Cockle Bay Park development – Response to RMS Review of Amended Concept Proposal for DA SSD7684

We refer to the letter from Roads and Maritime Services (RMS) – RMS reference SYD16/00625/08 – dated 30 January 2018 which details RMS' response to the amended concept proposal for development application SSD7684. Within this letter, RMS identified items which will require consideration as part of the determination of the development application and resolution in the preparation of any Stage 2 development application. Responses to the following RMS identified items are set out below. The number reference relates to the item number in RMS' letter.

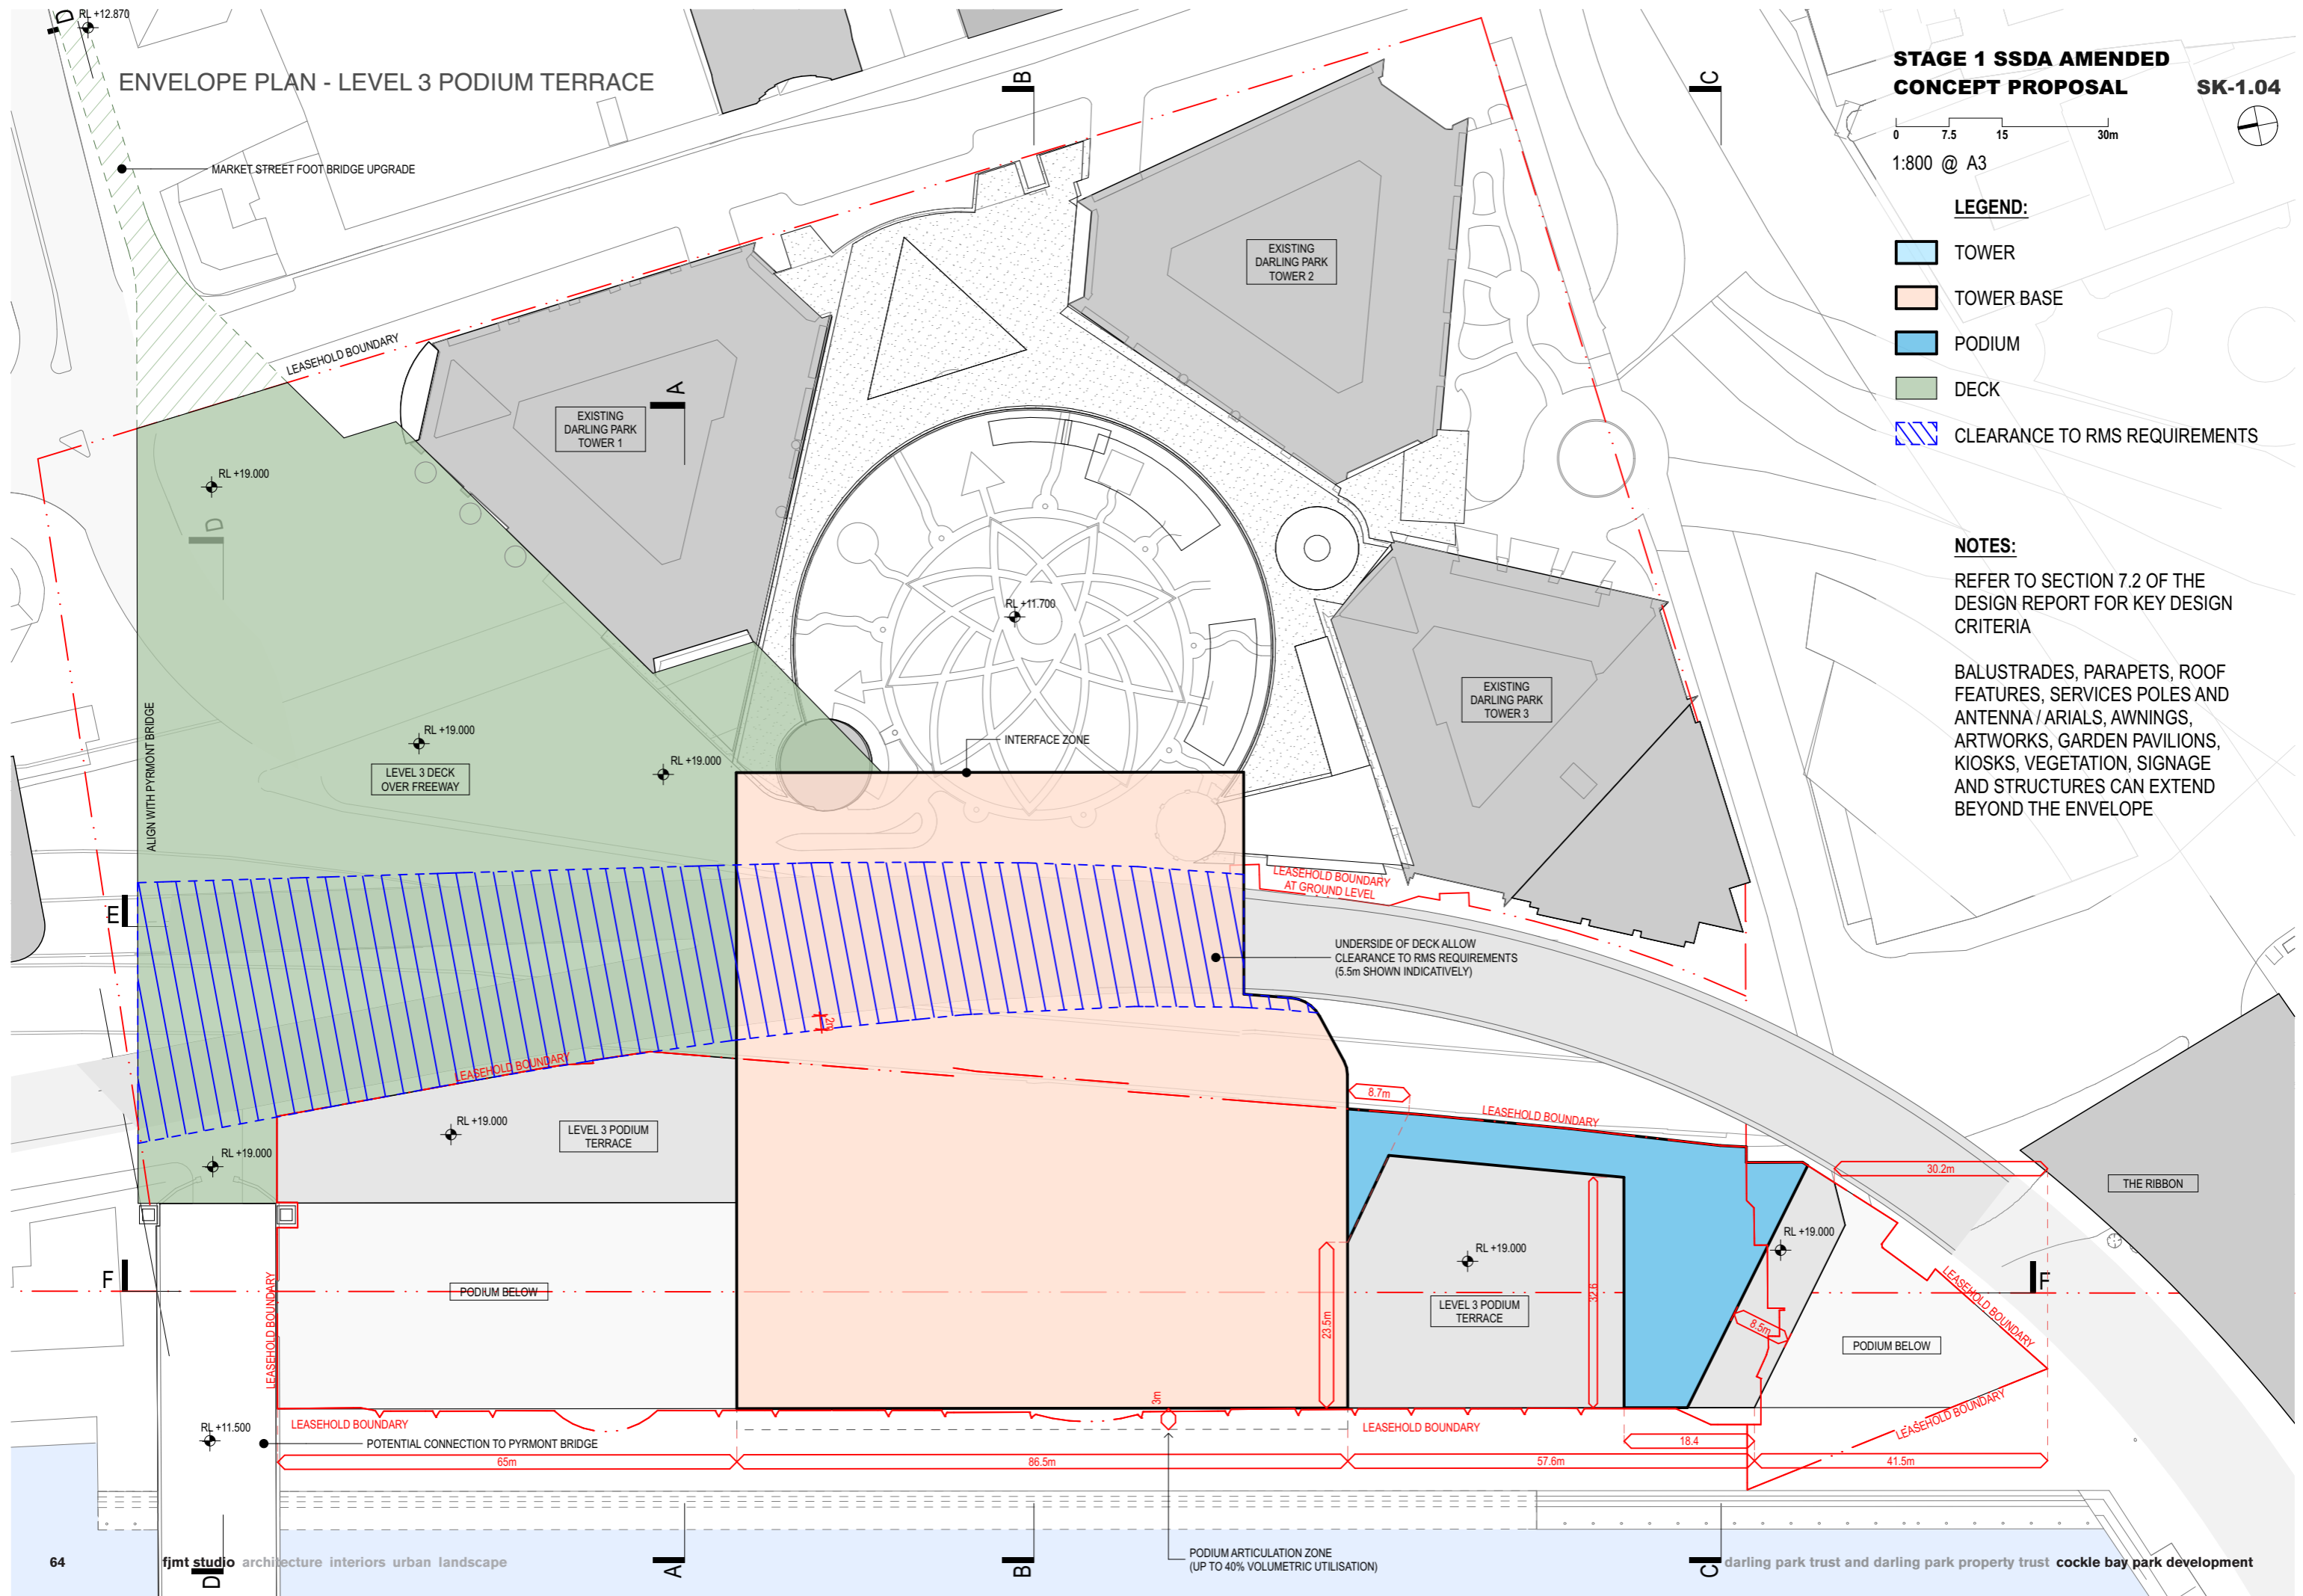
Consideration has been given to the allowance for vehicle roll at proposed pier locations and it is acknowledged that all existing signage that is impacted by the proposed works will need to be maintained or reinstated. Further, it is anticipated that coordination of ITS requirements associated with the Smart Motorways project will need to occur to confirm the appropriate allowances for minimum clearances.
